From: Stephen Rolley
Sent: 08 April 2021
To: Iqraa Malik
Subject: Re: Planning application

Dear Ms Malik,
I refer to the planning application I
have recently submitted online,
although without plans, for 6 The
Drive, East Preston BN161QH with
your above reference.
I had originally intended to
resubmit our existing plans which
were approved in 2012 and again in
2016.
On neither occasion did we
commence the building work in the
3 year timeframe.
After some thought after filing my
online application I decided to ask
our architect to amend the plans
with some minor alterations before
submitting them to you.
Unfortunately when I contacted the
architect the first available time he
is able to see me is this Thursday
18th March.
Obviously after the site visit on the
18th he will need some time to
draw the new plans which will leave
me a little tight, if not impossible
,to meet your deadline of the 23rd
March.
Is it possible therefore for you to
grant me an extension on the
deadline to enable me to continue
with this application for planning

BLOCK PLAN

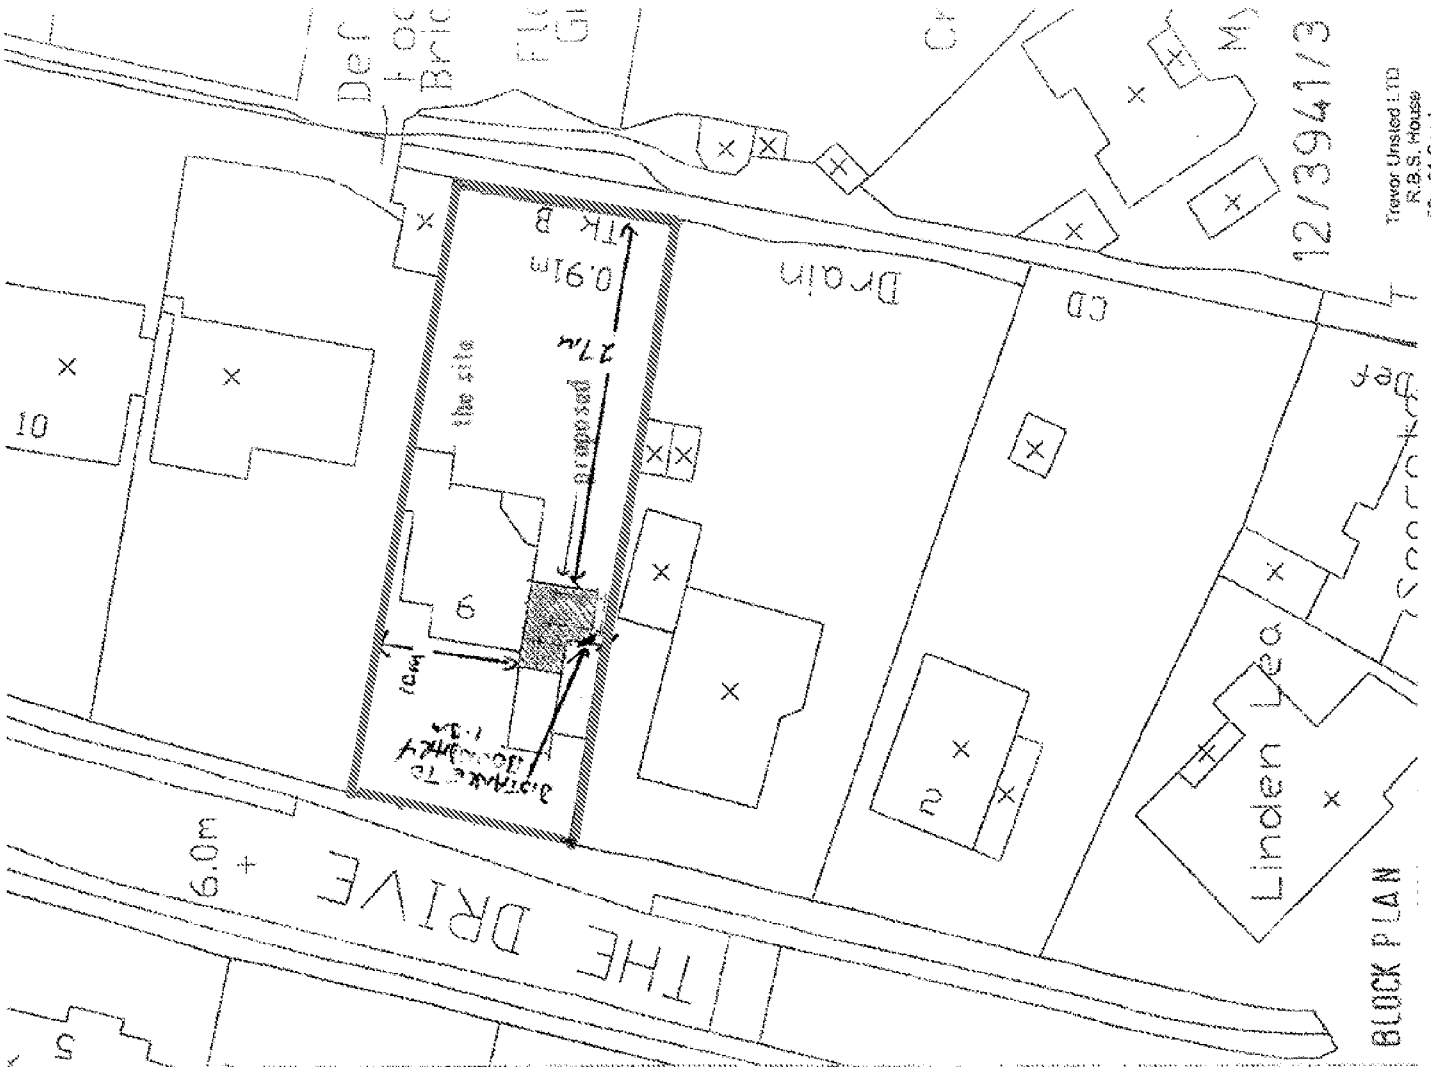
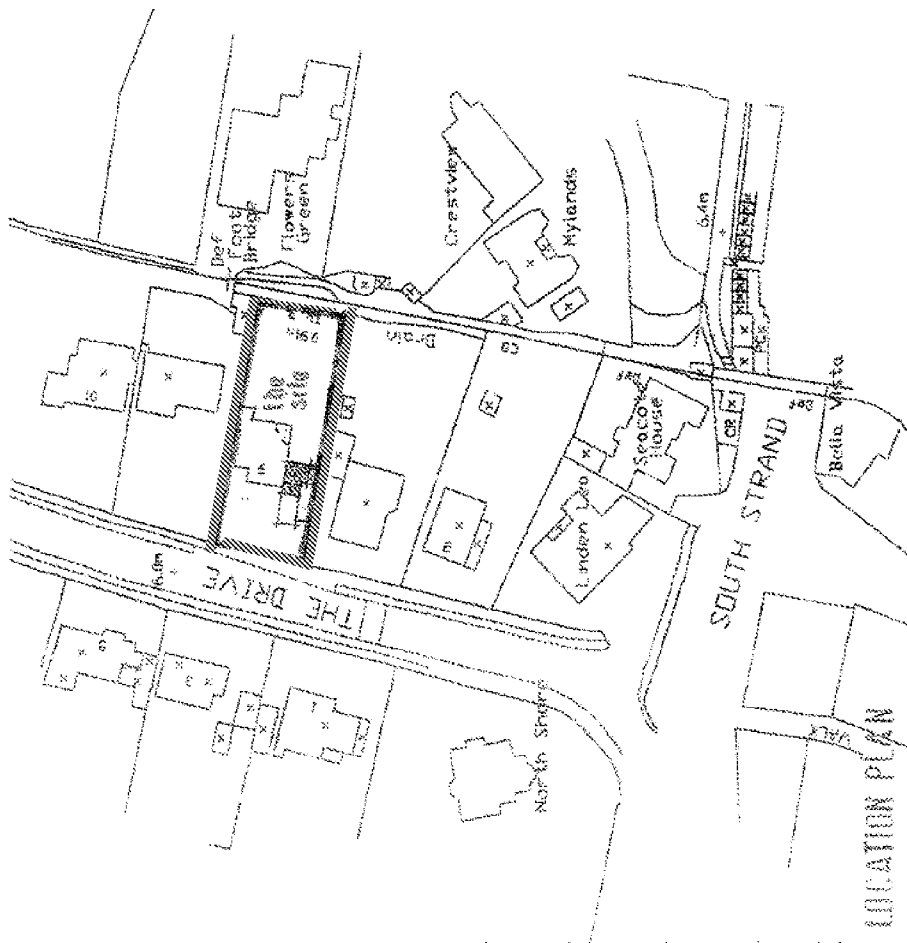
Thank you for providing the plans and CIL form. However, outline the new location plan appears to be in black and white. This requires a solid red outline. Along with this, the dates on the application form are too old and must be amended. With your permission, we are able to amend both this issues for you.

However, the proposed elevations and floor plans seem to be missing. Please submit these. Furthermore, the block plan requires dimensions from the proposed extension(s) to all site boundaries. Please review and amend accordingly.

Dear Ms Malik,
I have today delivered the completed CIL form and the block plan now showing distances from the proposed extension to our property boundaries to the Arun DC offices.
Hopefully the plans showing the floor plan and elevations have been located and my planning application can proceed.
Please let me know if you require anything further from me.
Thank you for your help.
Yours sincerely
Stephen Rolley

I will add the distance from the proposed extension to the site boundaries onto the block plan and deliver them to Arun.
